DRAINAGE AND TRANSPORTATION INFORMATION SHEET

Re: 6309 Camino Alto NW Residence (SAD 228)
Engineers stamp date 12-22-16 (D10 /D___)

This letter is in response to your informal comment email dated 12-16-16 and our subsequent meeting:

**ROYBAL RESIDENCE  
6309 CAMINO ALTO N.W.  
GRADING & DRAINAGE PLAN**

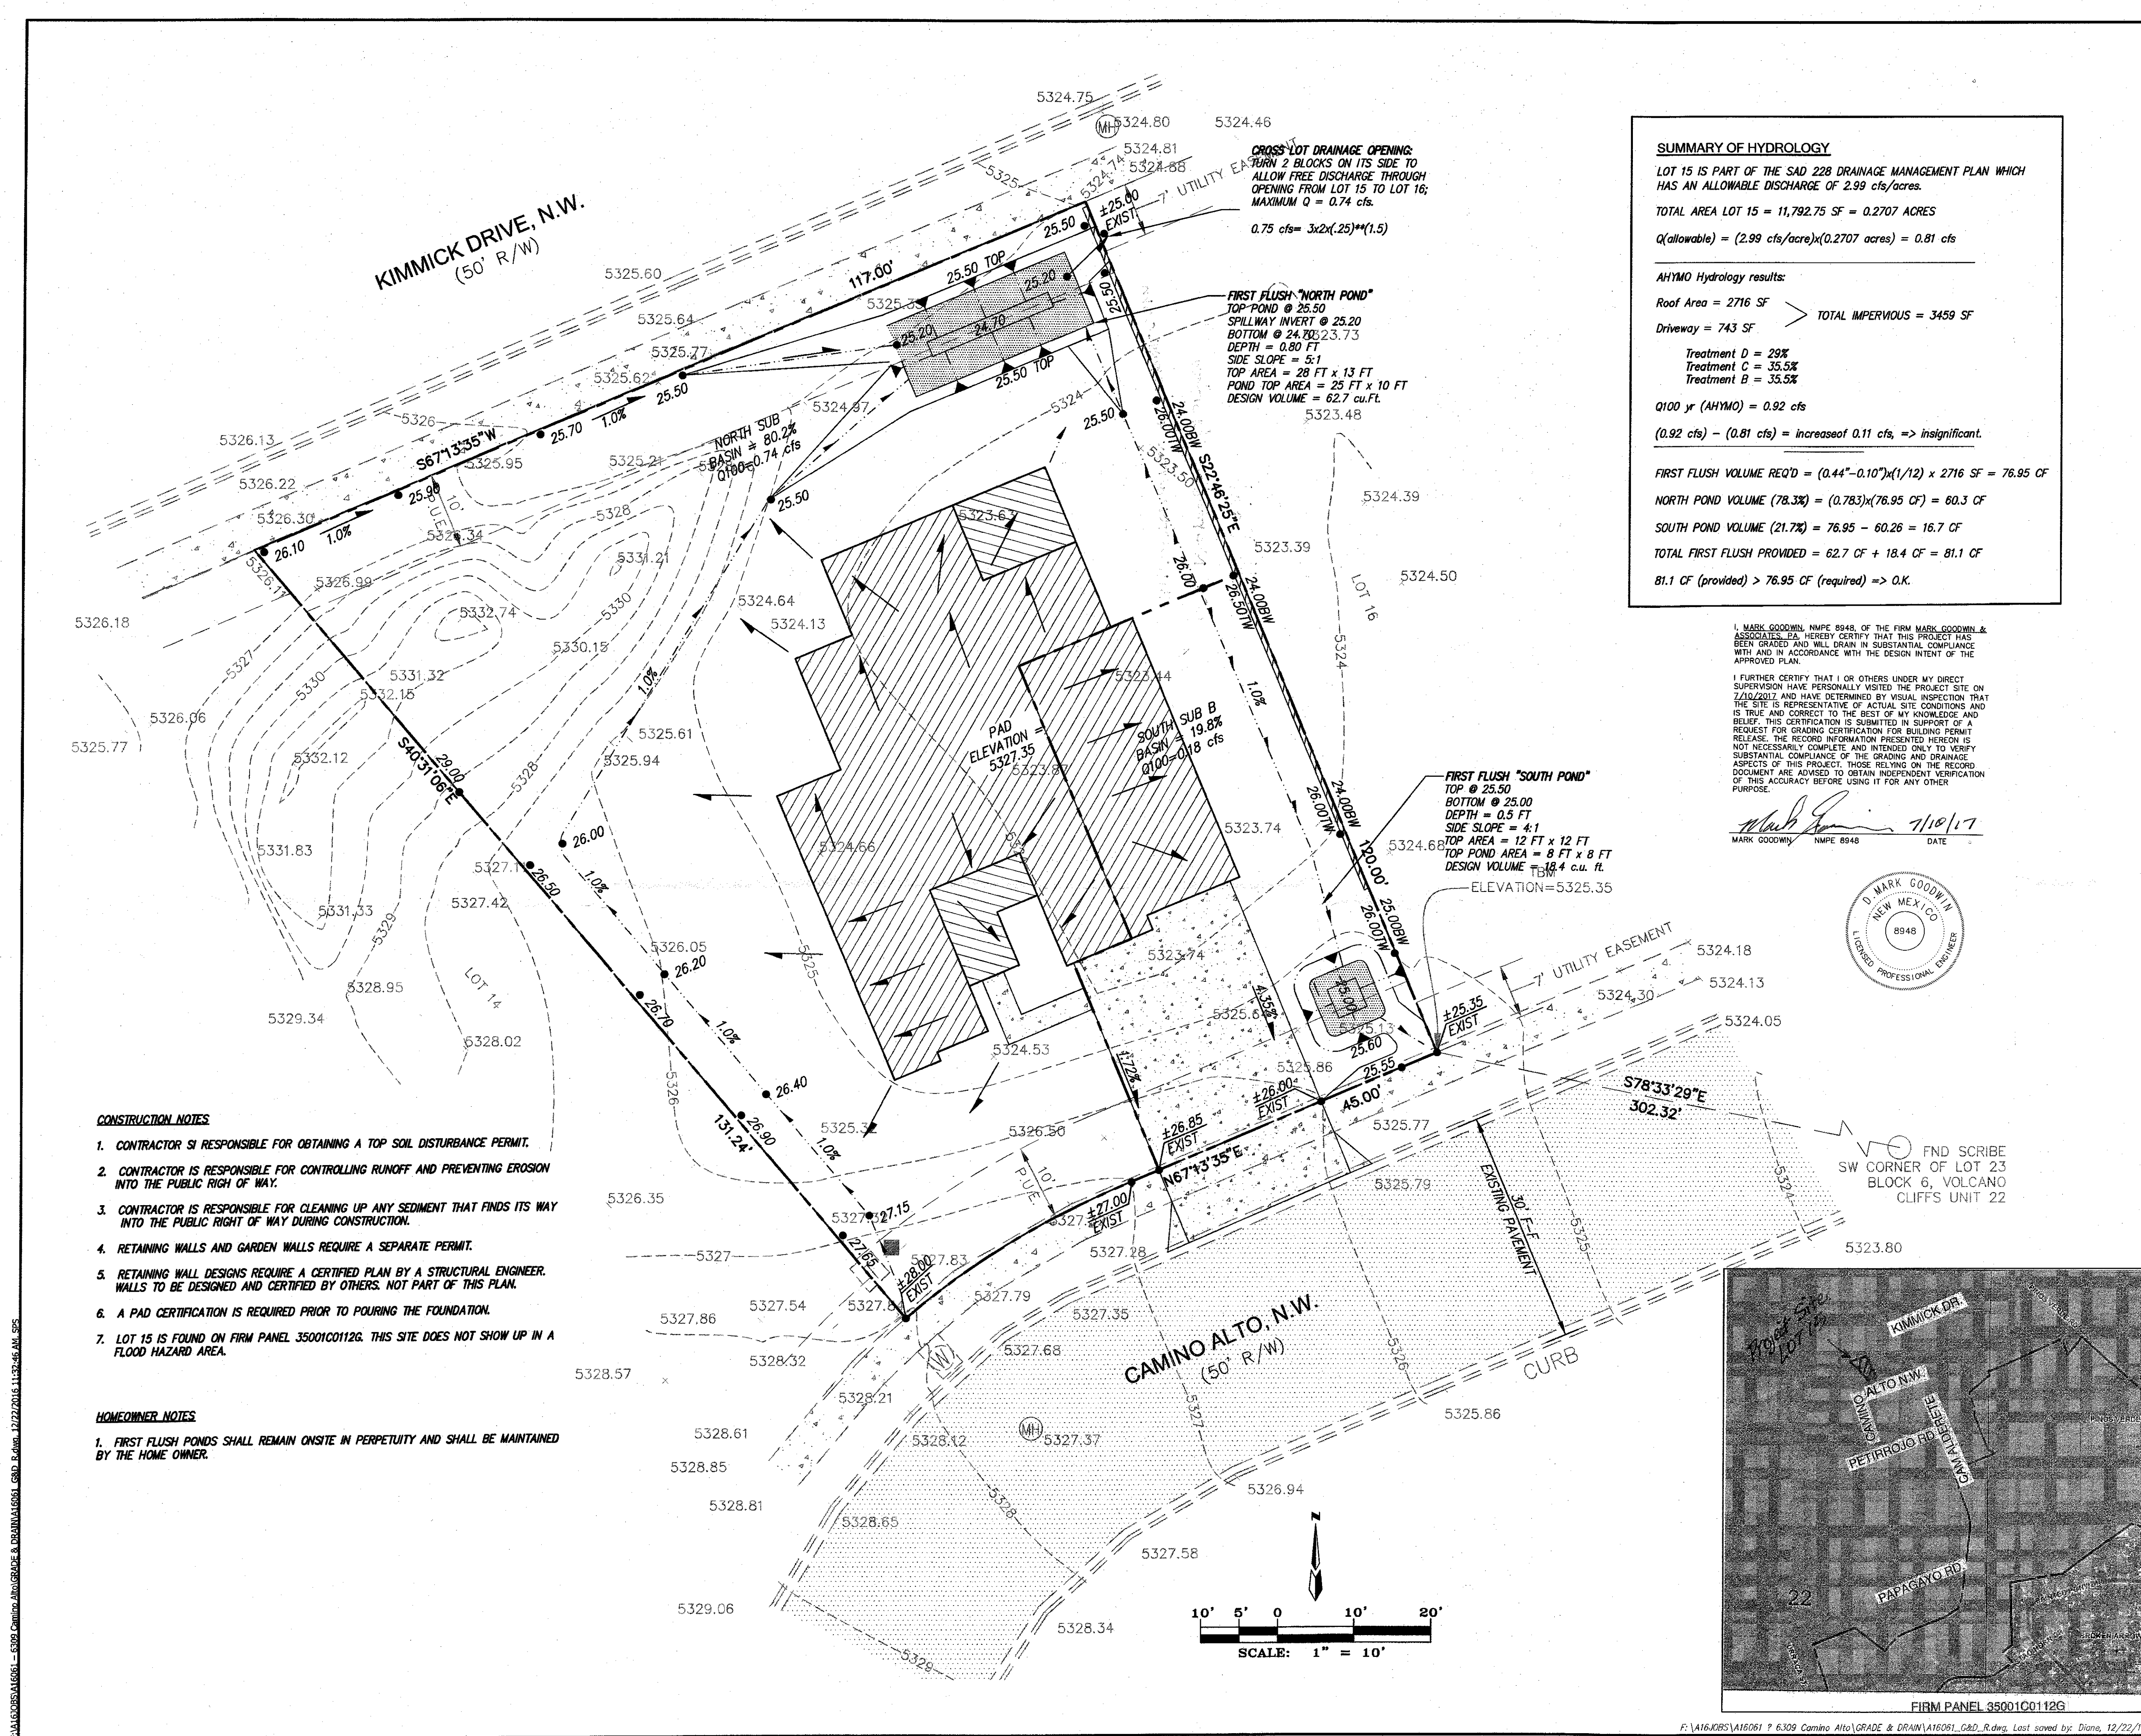
1. The flows from this site have been modified in response to our meeting. Part of the flow is directed to the first flush pond located at the NE corner of the lot with runoff overflow conveyed through two turned blocks at the boundary. A second first flush pond at the SE corner of the property with runoff overflow directed to Camino Alto road.
2. Opening size has been provided on the plan.
3. The spillway elevation from the pond is set at 0.2' higher than the adjacent property as shown on the plan.
4. The note has been added to the construction notes.
5. This has been provided on the plan.
6. This note has been provided in the construction notes on the plan.
